In reply please quote: 16/25280
Your reference: SSD 7917 MOD 1

**SSD 7917 MOD 1 - RESPONSE TO SUBMISSIONS - SECTION 96(1)
MODIFICATION TO THE WAREHOUSE / DISTRIBUTION & INDUSTRIAL
FACILITY, HORSLEY DRIVE BUSINESS PARK, LOT 3 – 6 BURILDA CLOSE,
WETHERILL PARK**

I refer to the notification of the Response to Submissions of the above Modification to a State Significant Development. Council officers have reviewed the information and provide the following comments.

DRAWING TITLE
SITE PLAN

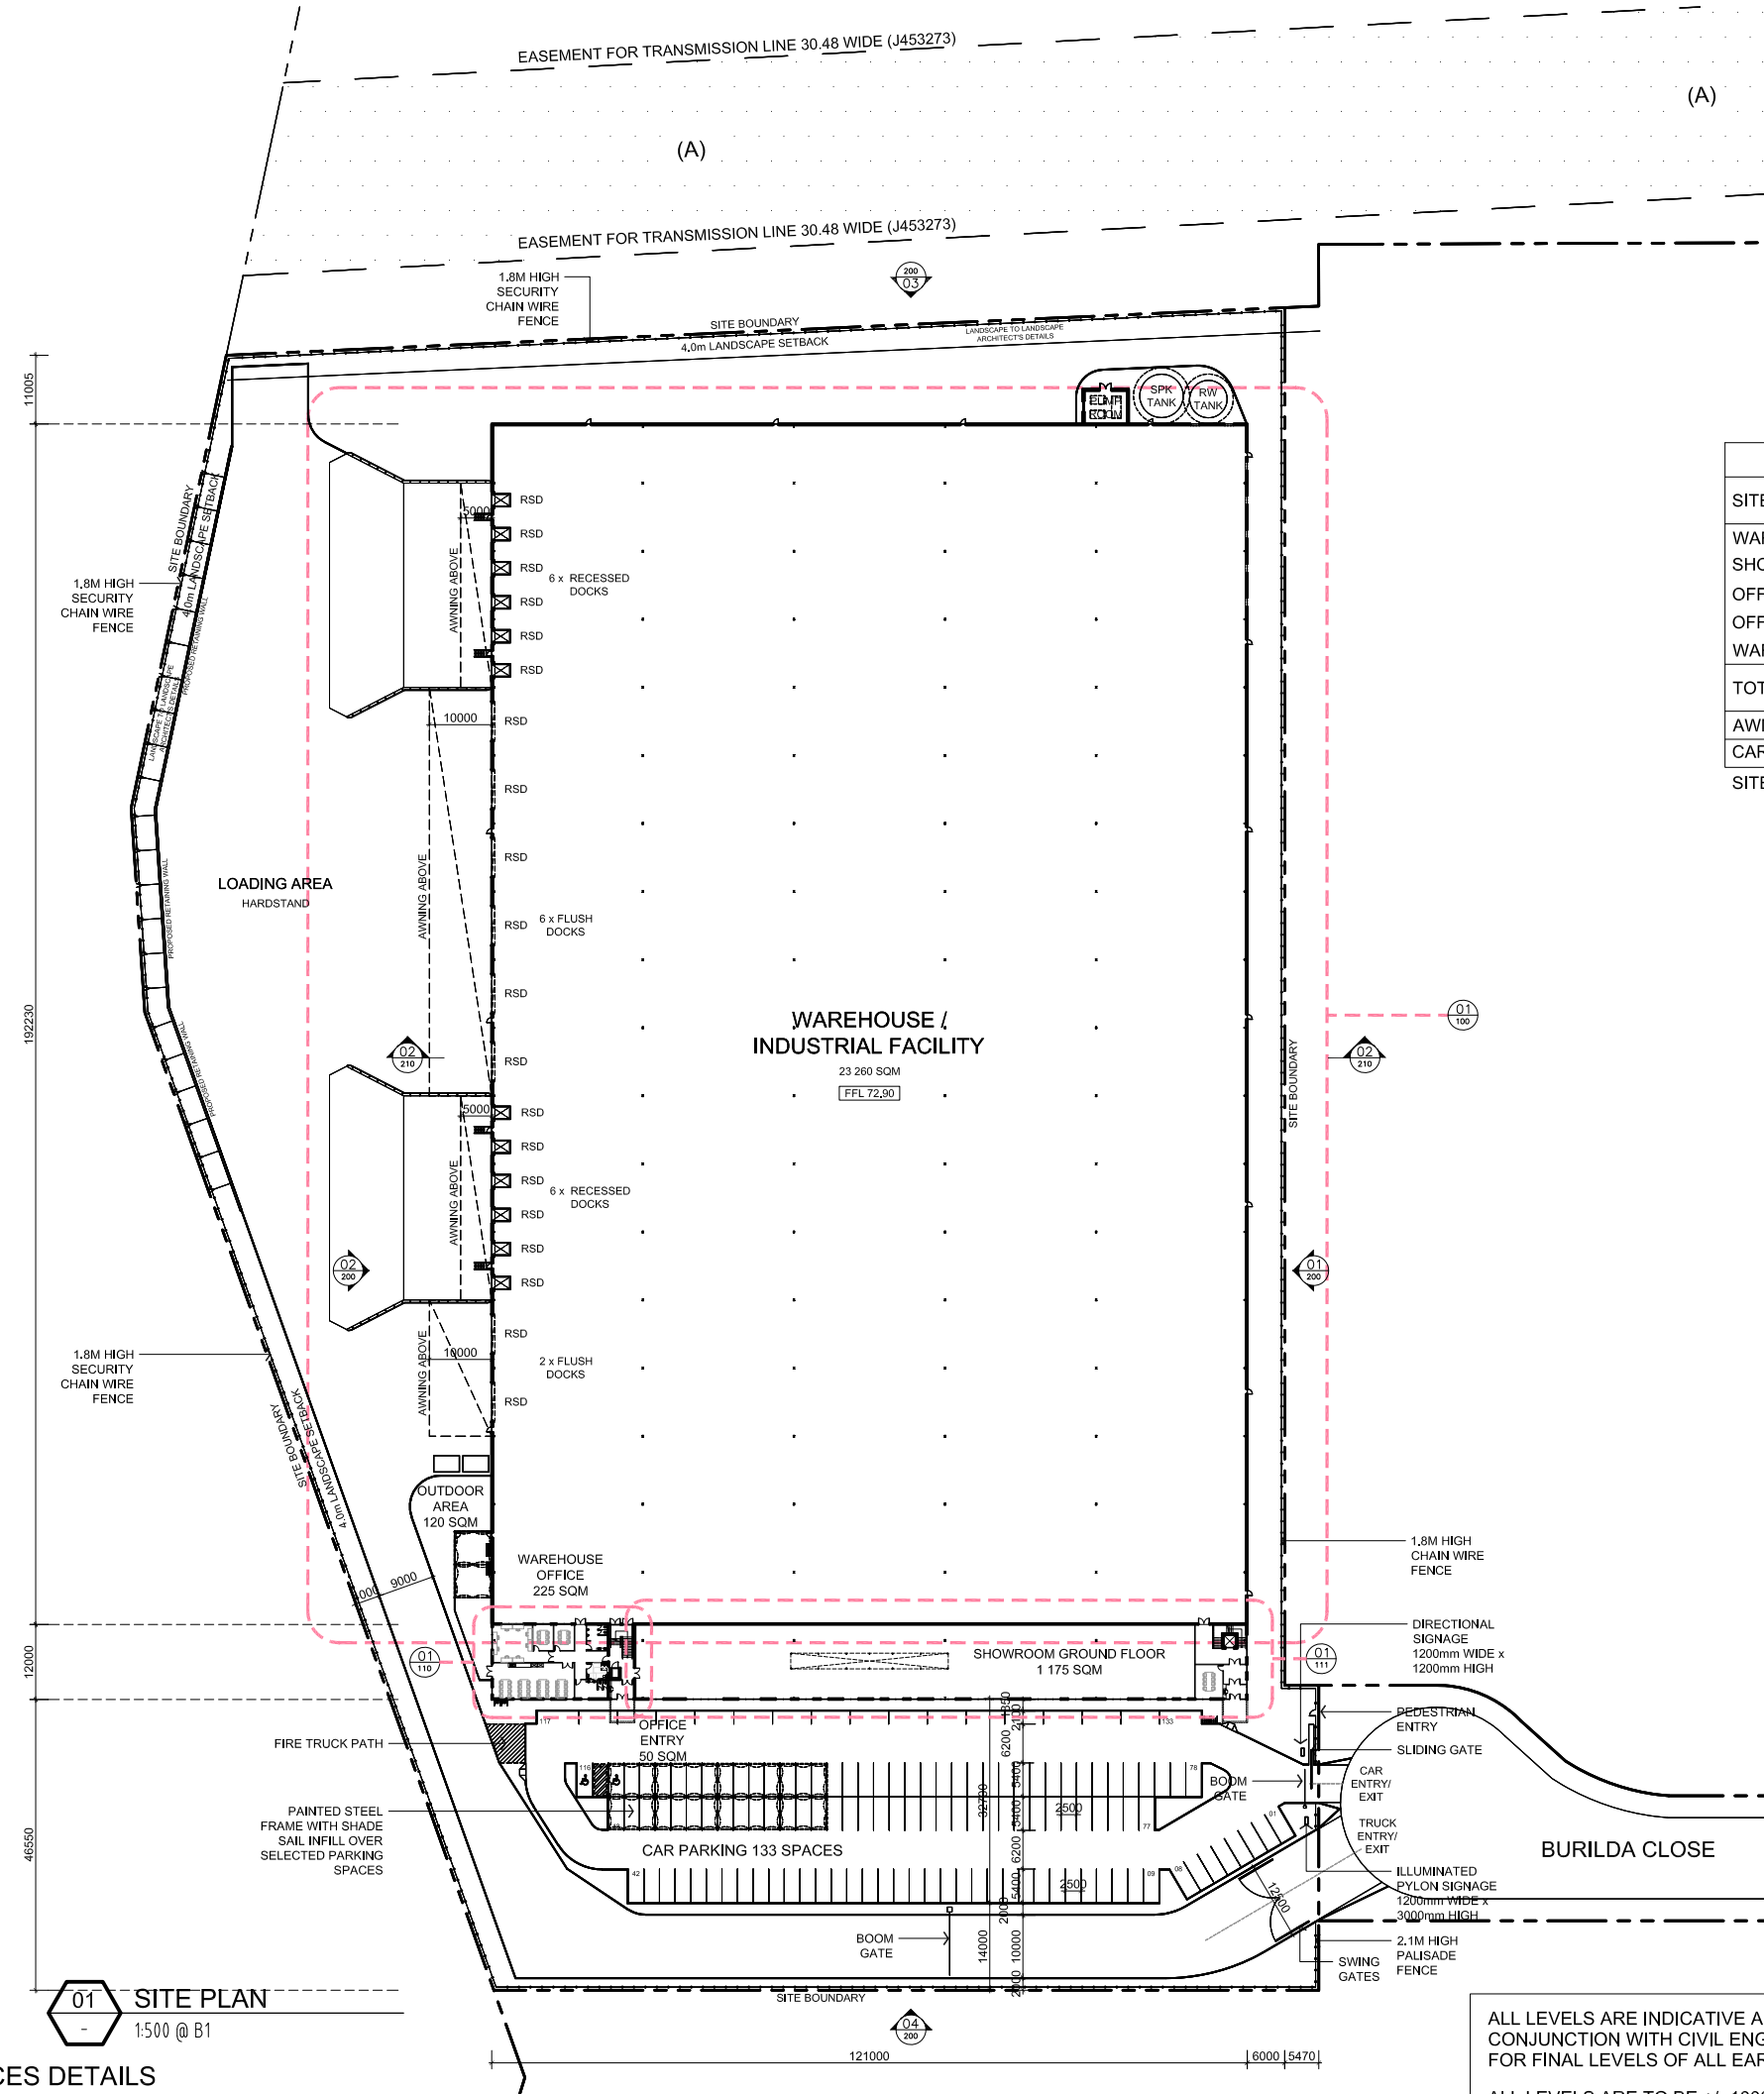
Council's Environmental Management division has again determined that insufficient information has been submitted for SSD 7917 in relation to the waste storage area. It is recommended that a covered, bunded and drained waste storage area as a standard condition, regardless of the nature of the proposed development and the reported contents of the waste streams.

Recommendation: That all contingencies of waste storage are addressed, including bin leakage, bin washing and any future change of use of the premises. Modified site

plans showing the waste storage area being covered, bunded and drained to sewer are requested.
